Development Facilitation Team (DFT) – Review Comments

Project No: PR-2019-002089 Date: 12/06/2023 Agenda Item: #8 Zone Atlas Page: K-12

Application For: SD-2019-00196-PRELIMINARY/FINAL PLAT (DHO)

Project Name: 239 - 243 Anna Maria Pl SW

SIDEWALK EXHIBIT

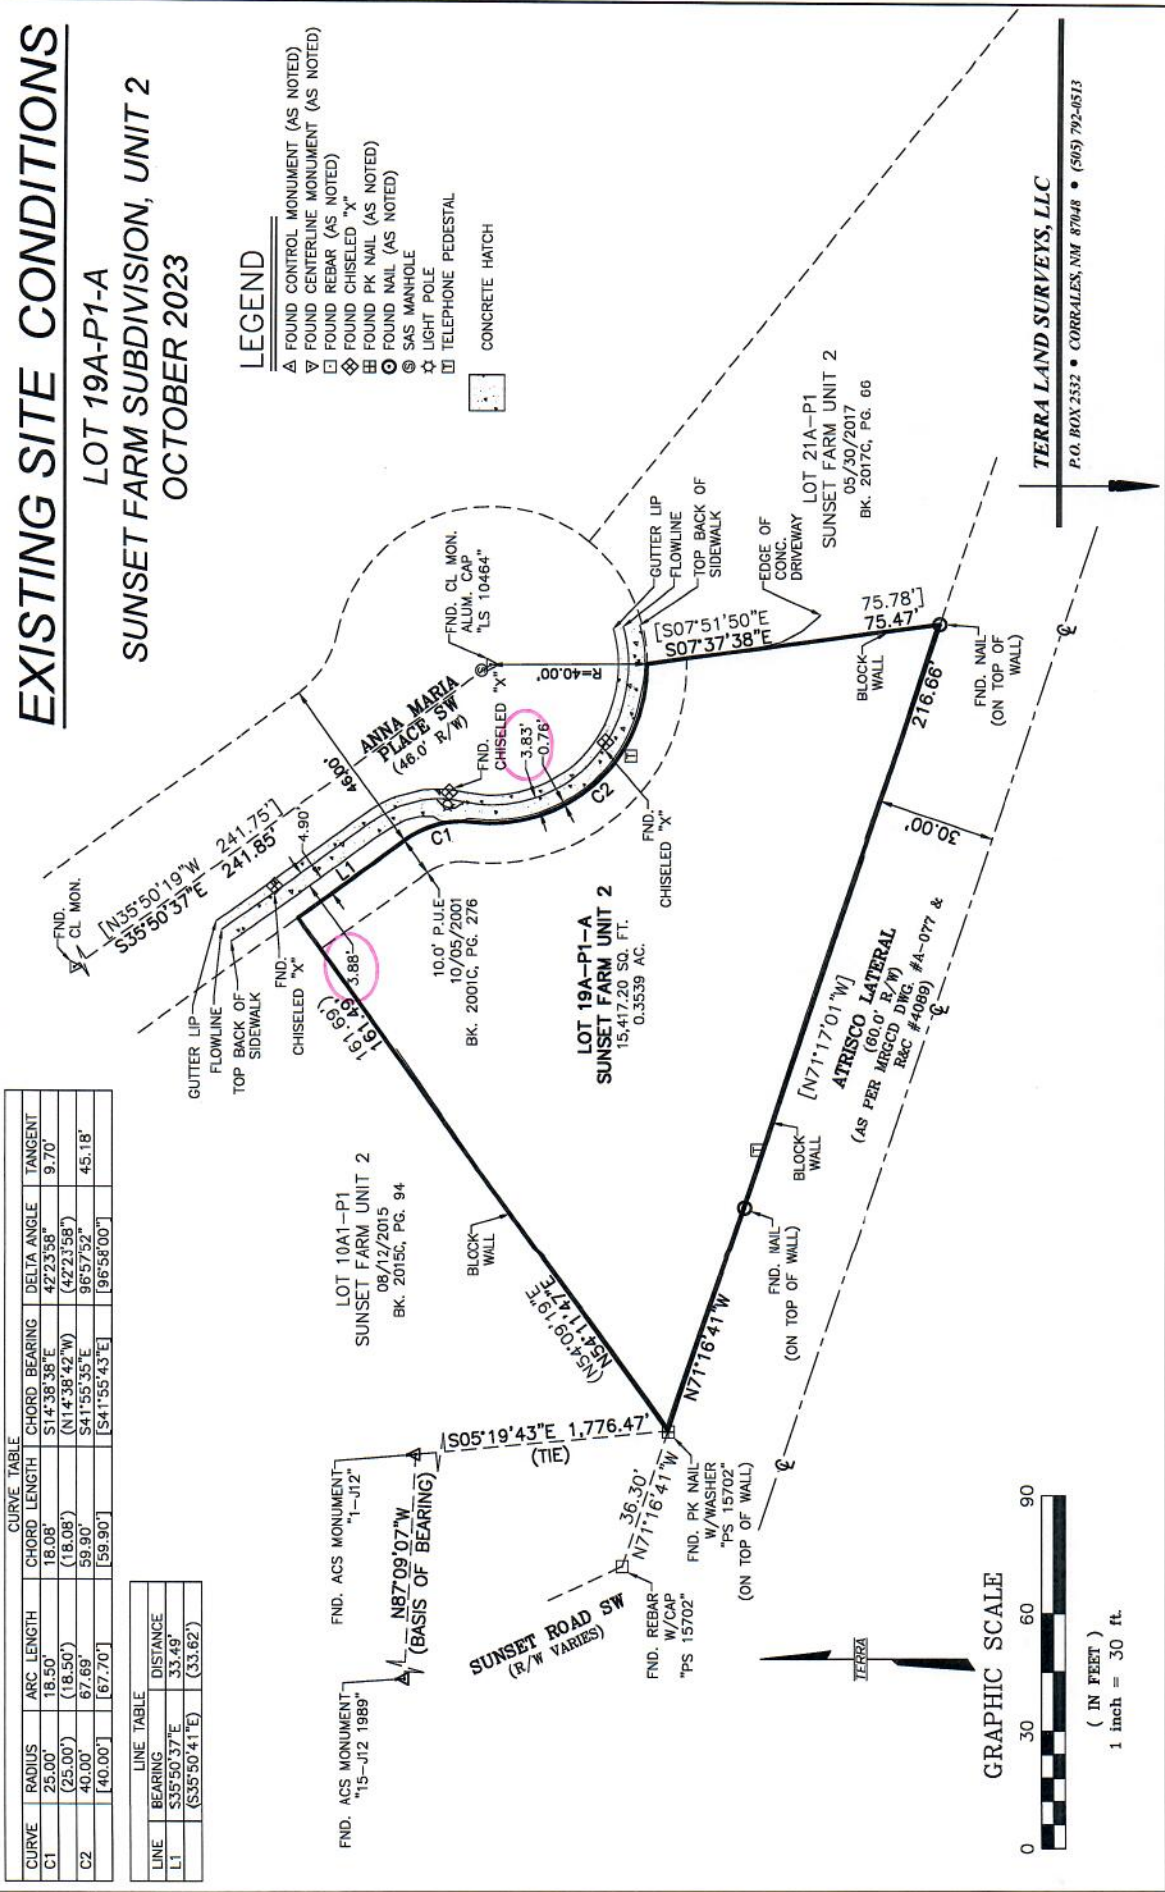
Per section 7 of the DPM, Table 7.2.29. in regards to Sidewalk width requirements and its landscape buffer, Anna Maria Pl SW is a local street: a 5-foot sidewalk and a 4-6 -foot Landscape Buffer is required.

The applicant is requesting to maintain the existing sidewalk width along Anna Maria PL width at 3.83 feet. This is a consistent sidewalk width throughout the subdivision this lot is located within.

Planning has no objections to the request for maintaining the existing sidewalk width at 3.83 feet, but defers to Transportation.
